Phone: 0300 123 6780
Email: Kathryn.Walsh@lancashire.gov.uk
Your ref: 3/2024/1000
Our ref: 3/2024/1000/HDC/KW
Date: 13 March 2025

Location: Barn at Greengore Hill Lane Hurst Green BB7 9QT
Proposal: Change of use of land to form extended residential curtilage and construction of residential storage building. Formation of new vehicular access from Hill Lane for new agricultural building.
Grid Ref: 367369 438921

7042 -P01 REV A

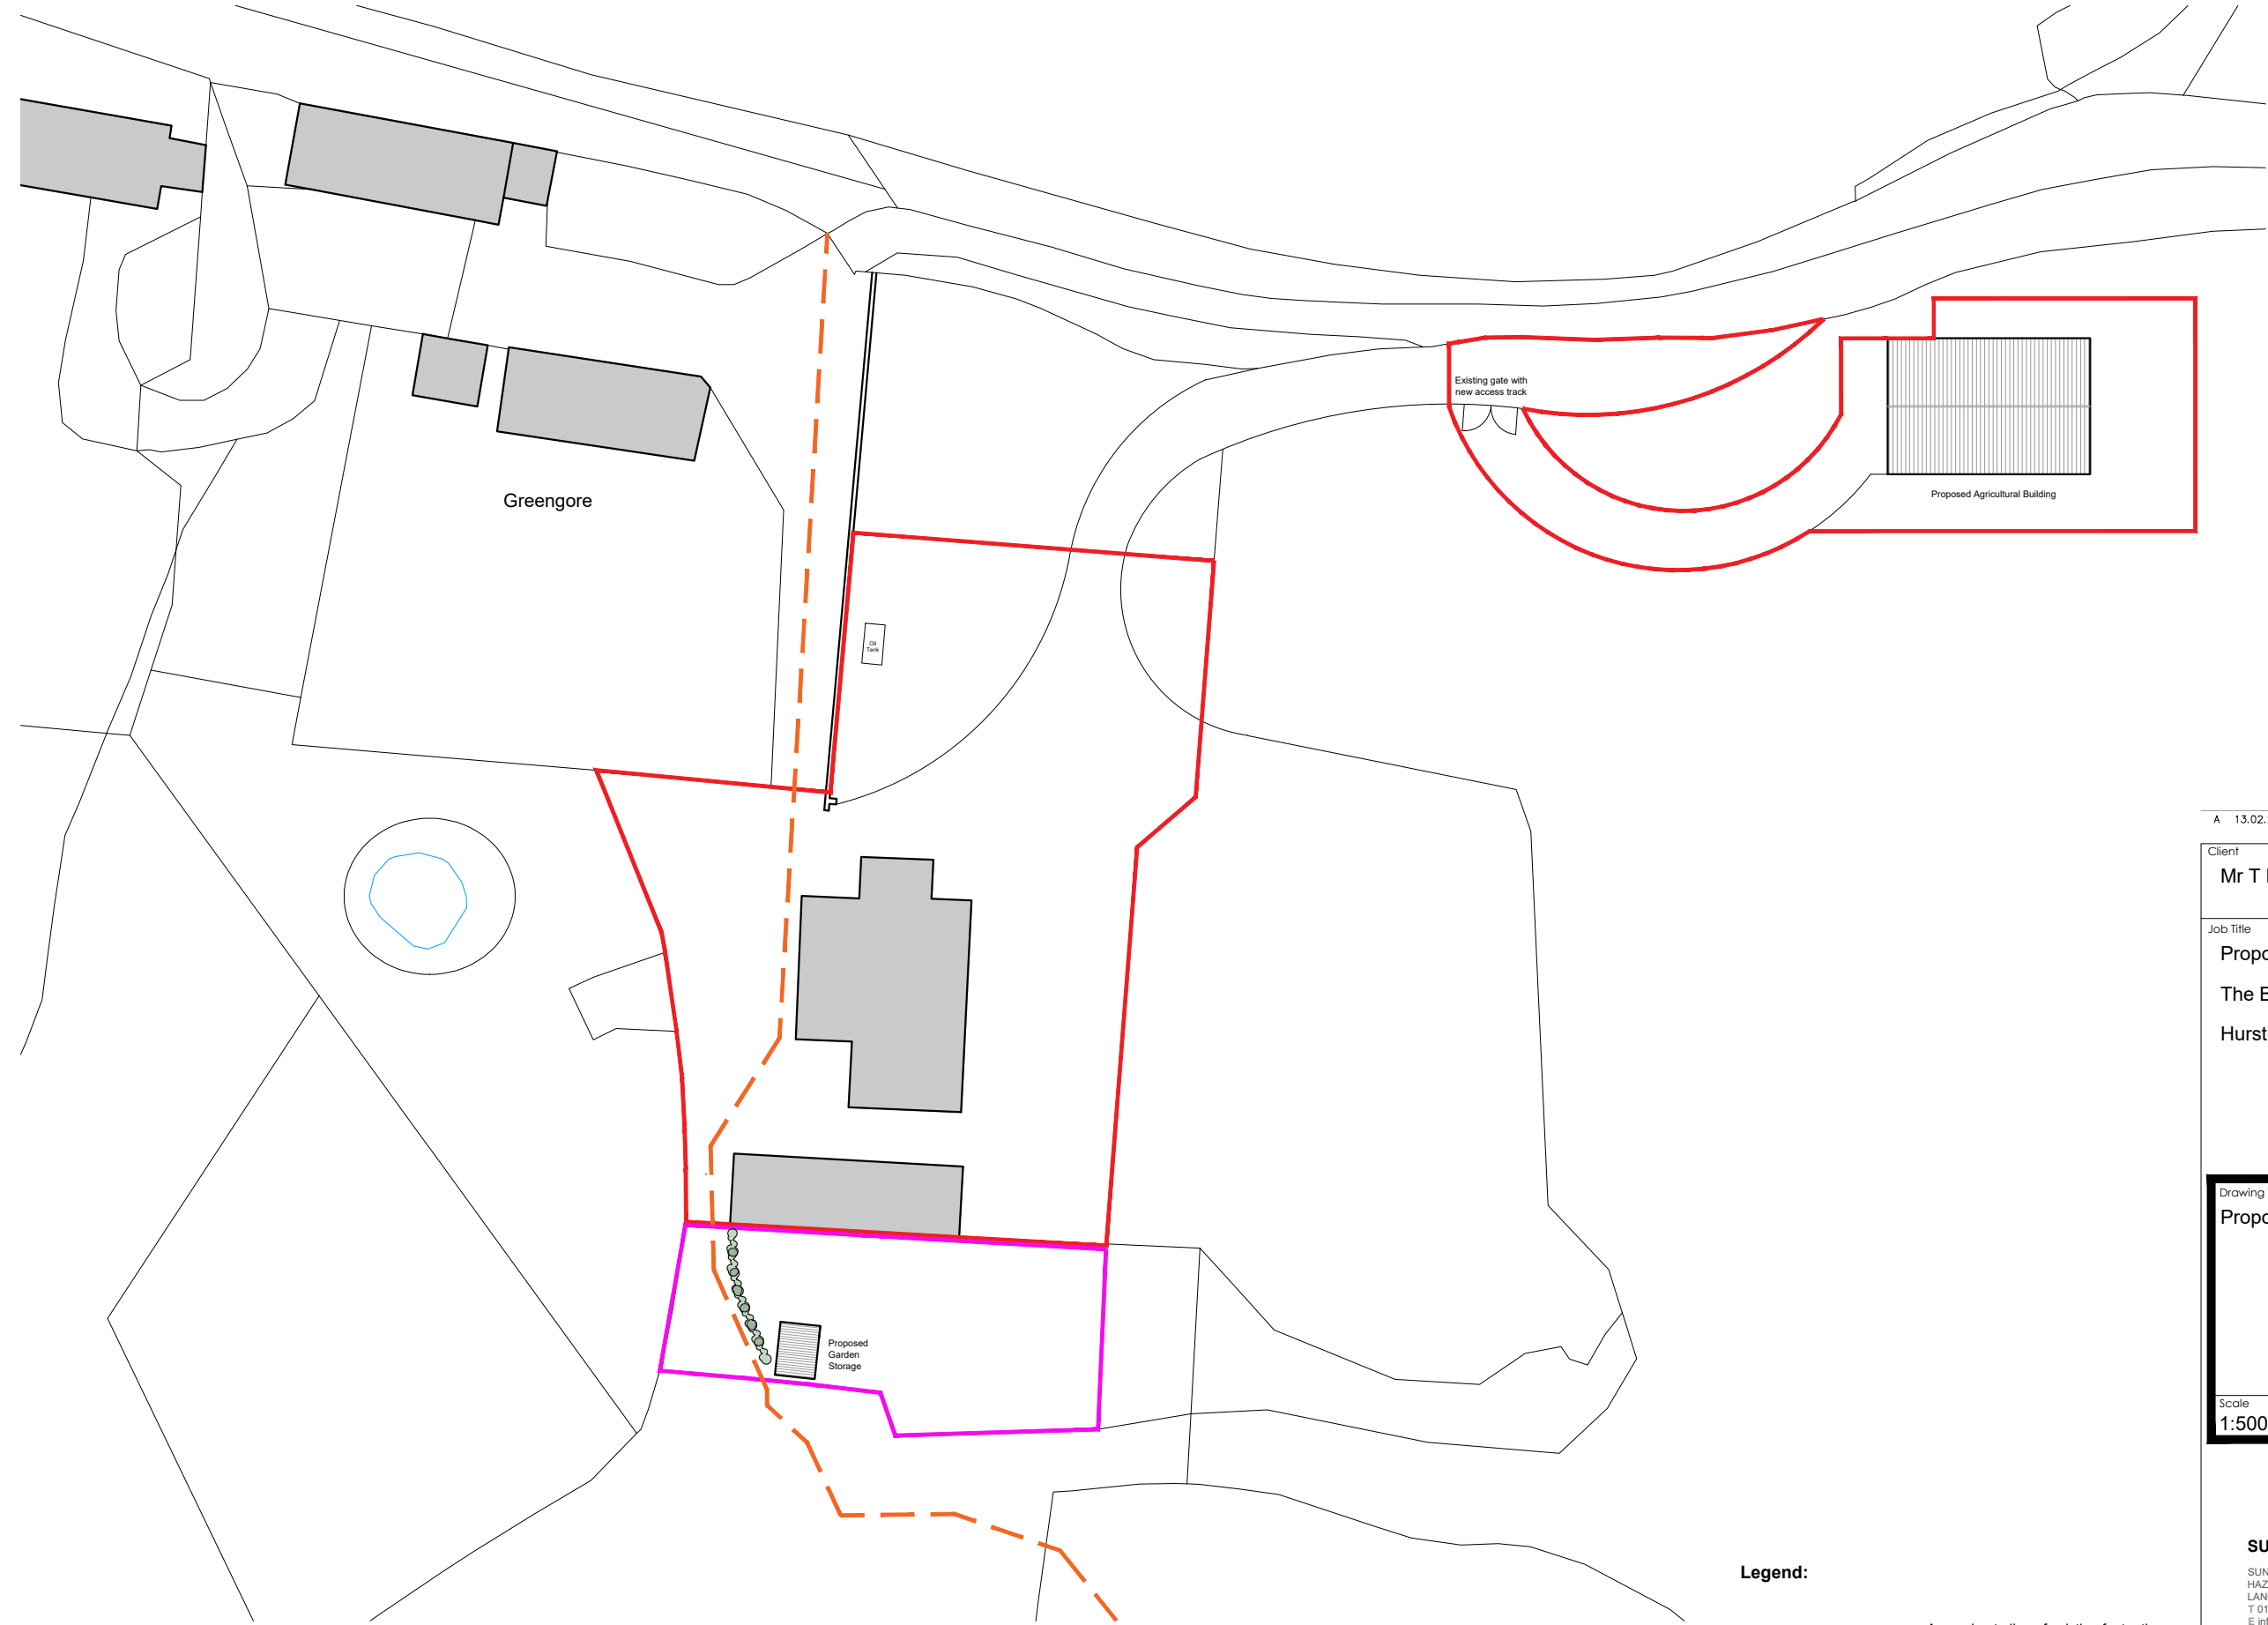
The development will be accessed from a private access track which also forms a number of Public Right of Ways, including BW0303008 and FP0303017 which run adjacent to the access and through the applicant's site. The public footpaths must not be obstructed during the proposed developments. The granting of planning permission does not constitute the diversion of a Definitive Right of Way. The applicant should be advised to contact Lancashire County Council's Public Rights of Way section by email on PROW@lancashire.gov.uk, quoting the location, district and planning application number, to discuss their proposal before any development works begin.

The applicant must be certain that they have private vehicular rights along this public path before driving on it either during construction or for subsequent access. Without private vehicular rights or permission from the owner it is a criminal offence to drive a motor vehicle on the public path.
